# OXFORDSHIRE COUNTY COUNCIL'S RESPONSE TO CONSULTATION ON THE FOLLOWING DEVELOPMENT PROPOSAL

**Application no:** 22/03063/F

**Proposal:** Erection of 126 dwellings with access from Camp Road, provision of public open space and associated infrastructure

**Location:** Land East Of Larsen Road, Heyford Park

Road 1  
Horiz. 1:500 Vert. 1:50

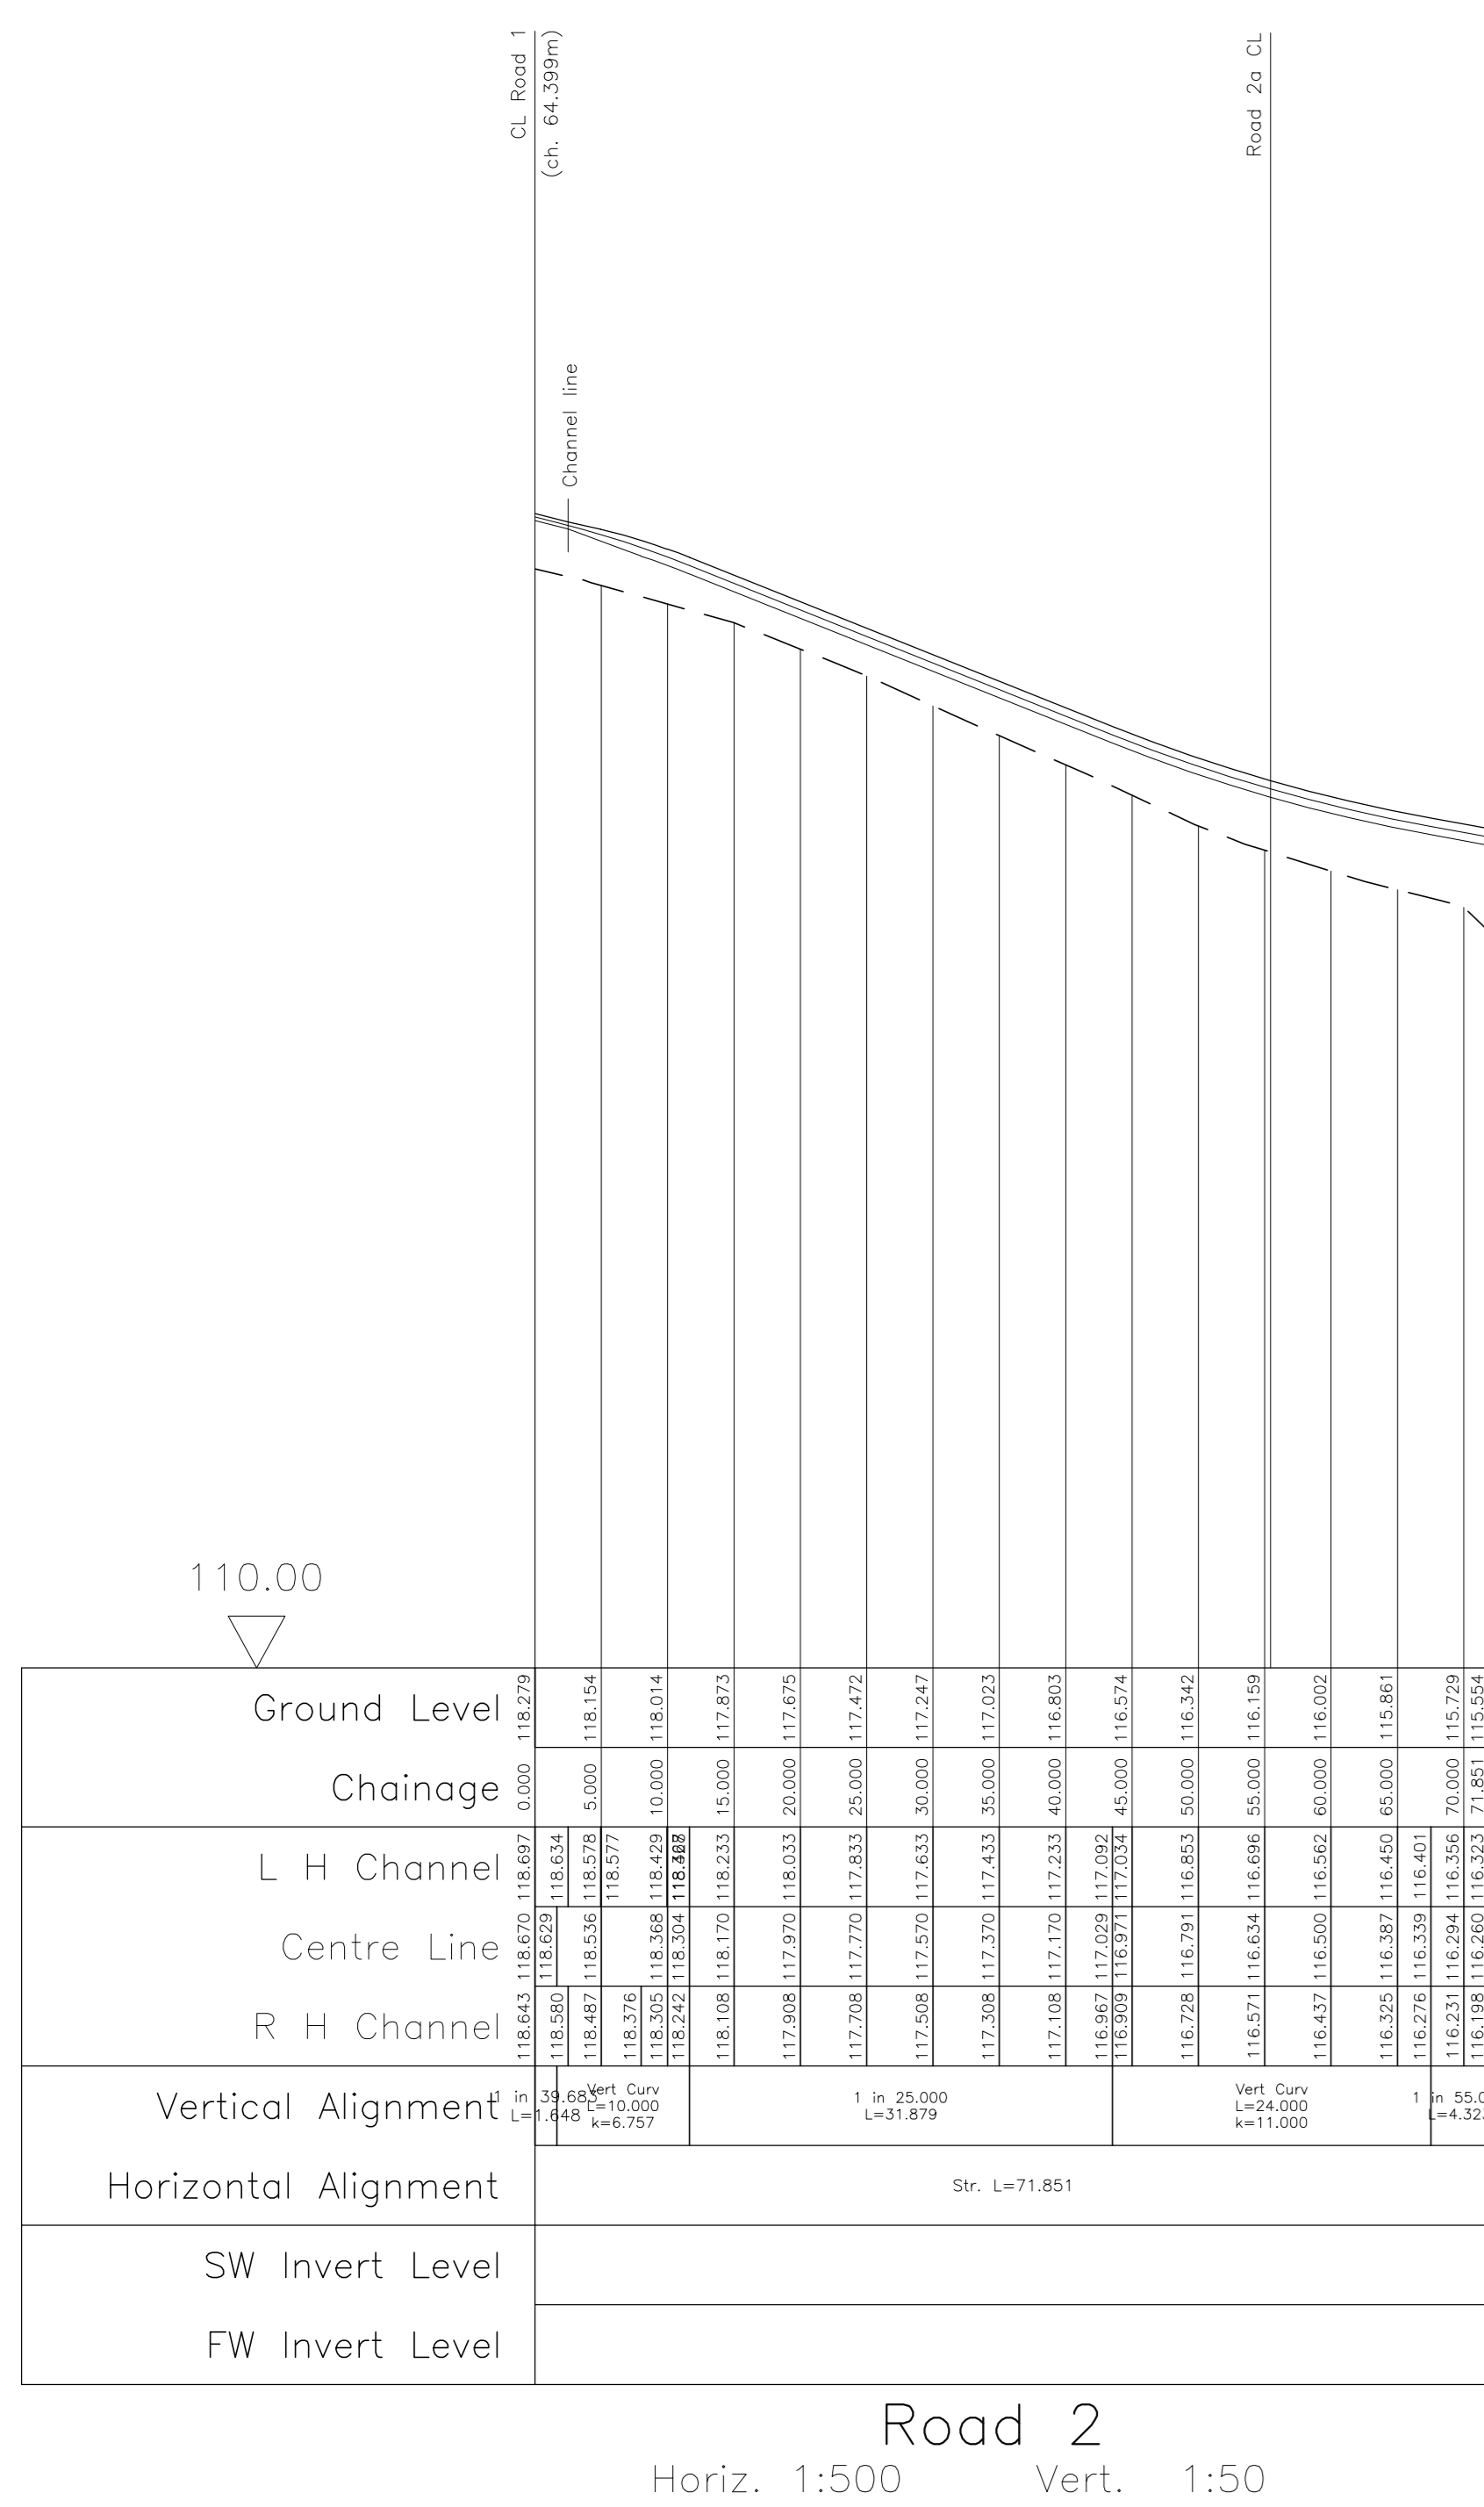
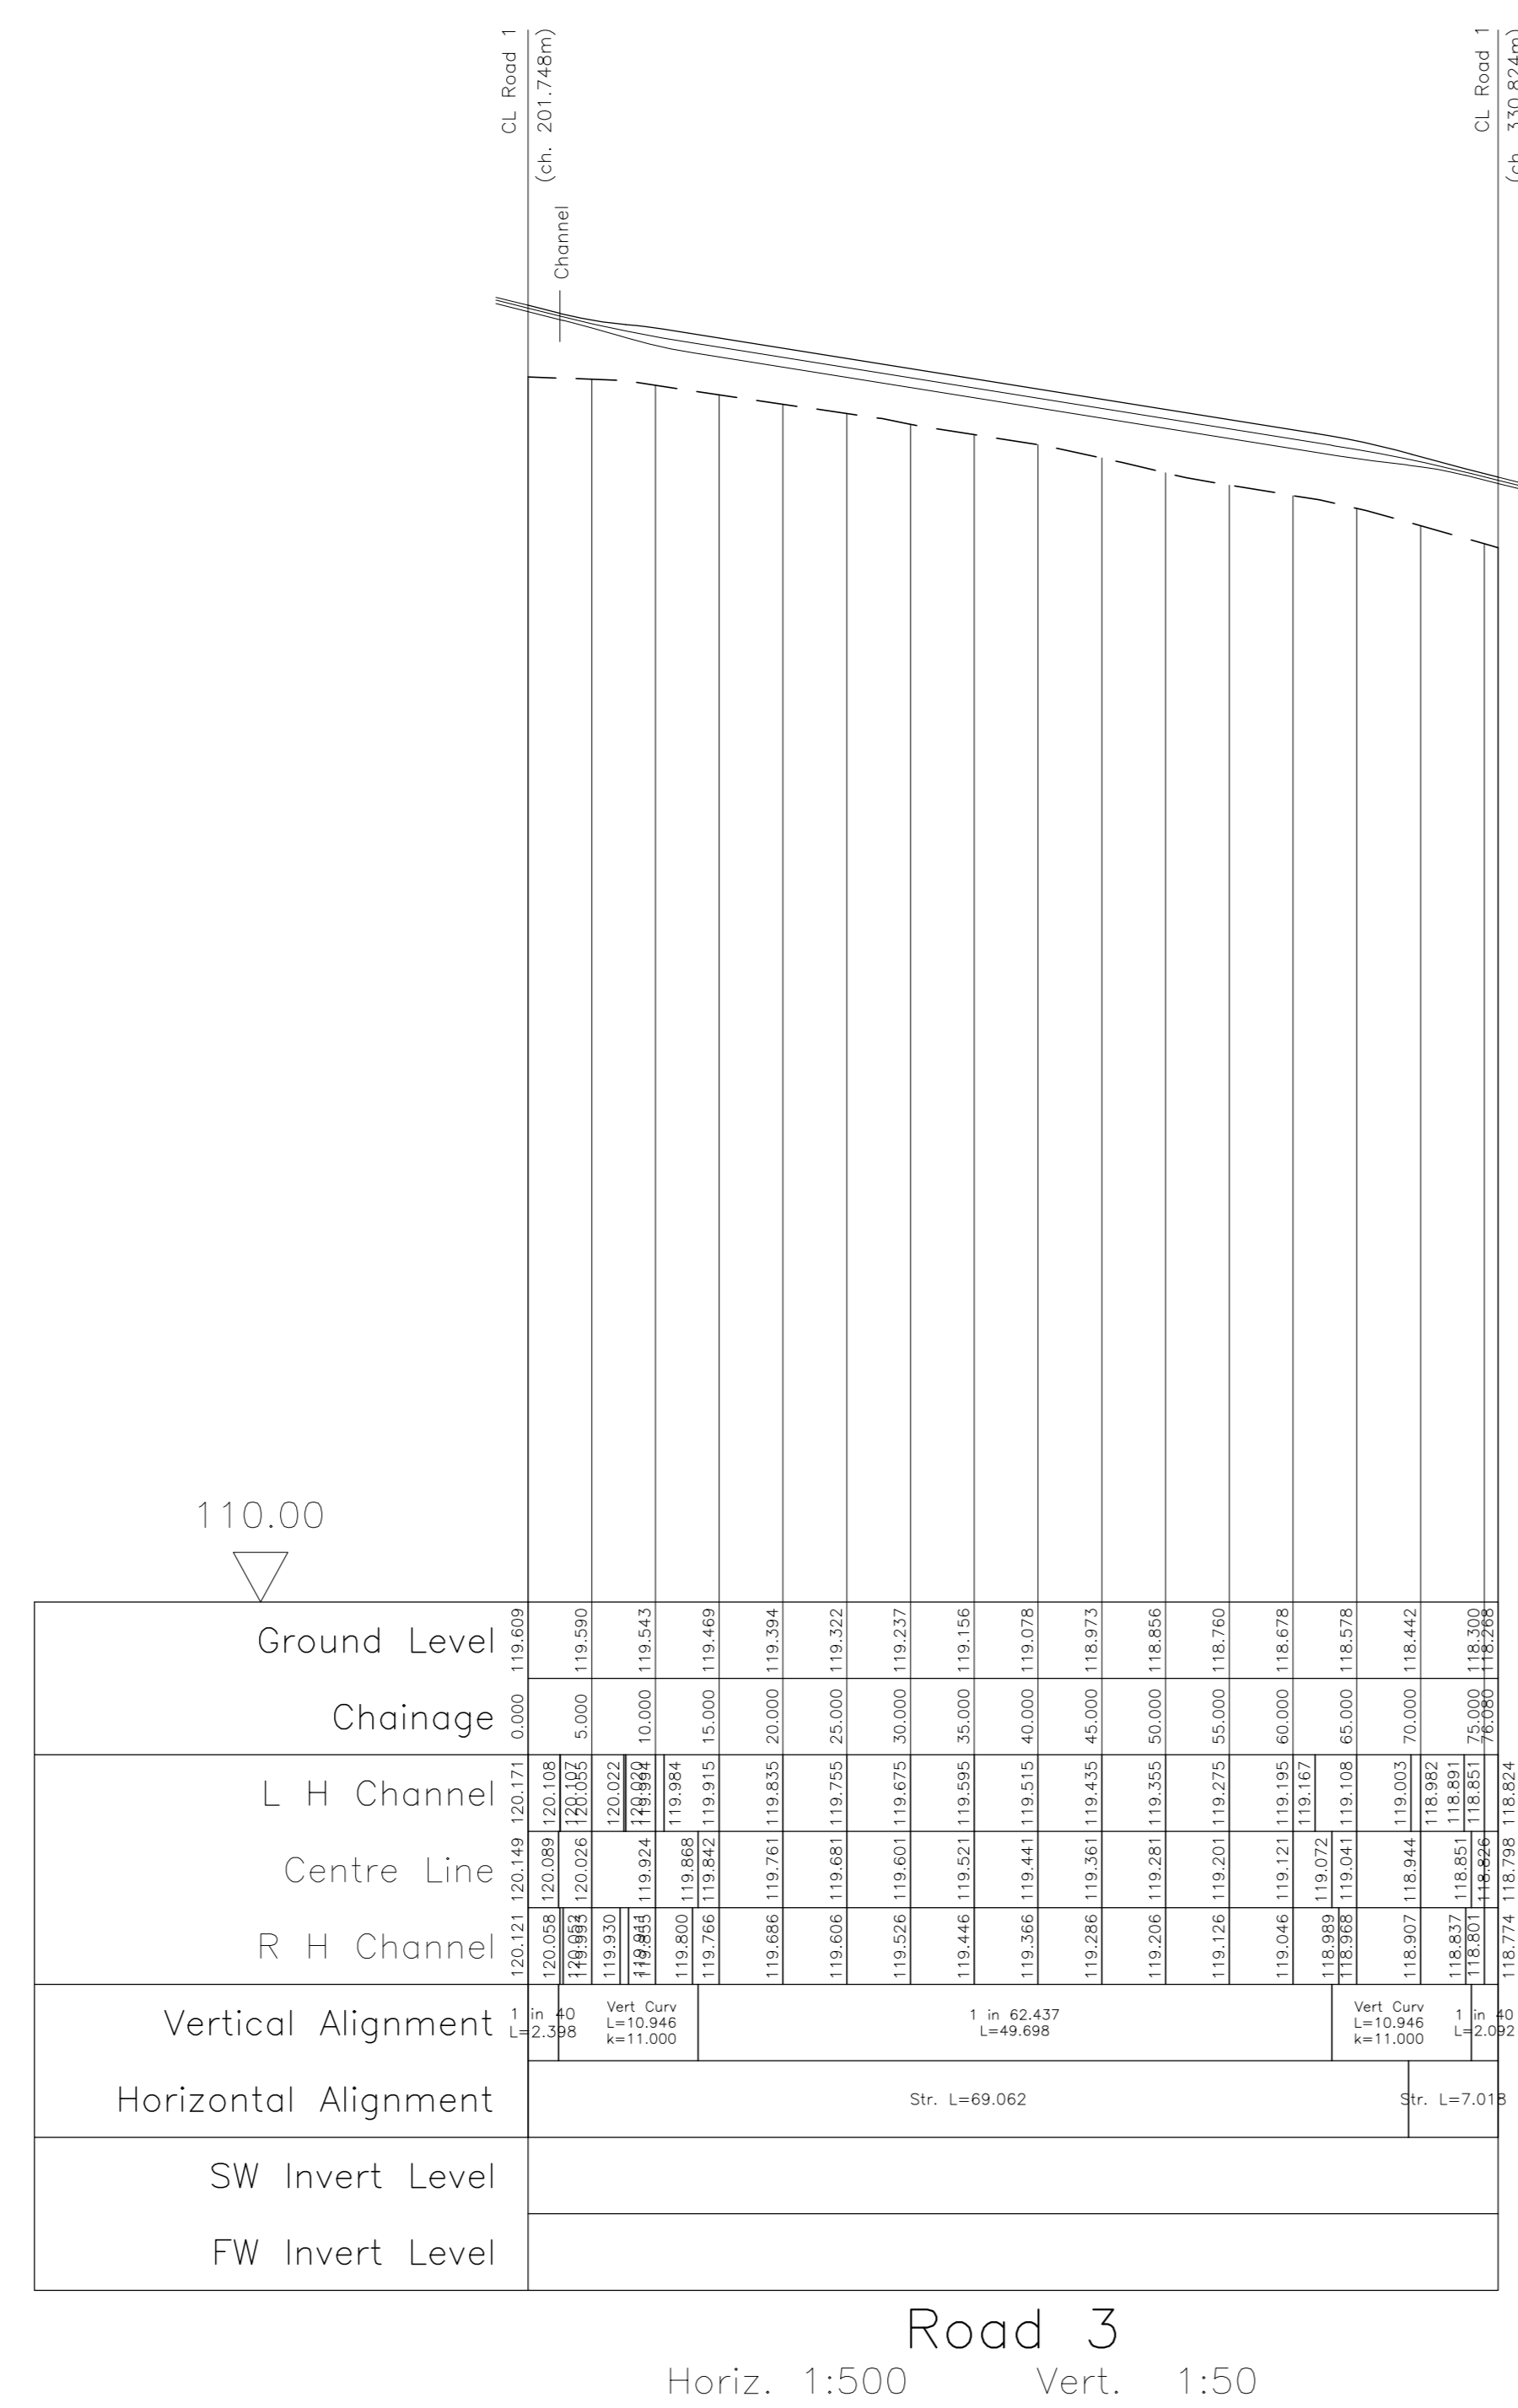
- A long section indicating the vertical alignment will be required to determine appropriate carriageway and footway gradients. They will need to be DDA compliant i.e. maximum 1:20 or 5%.
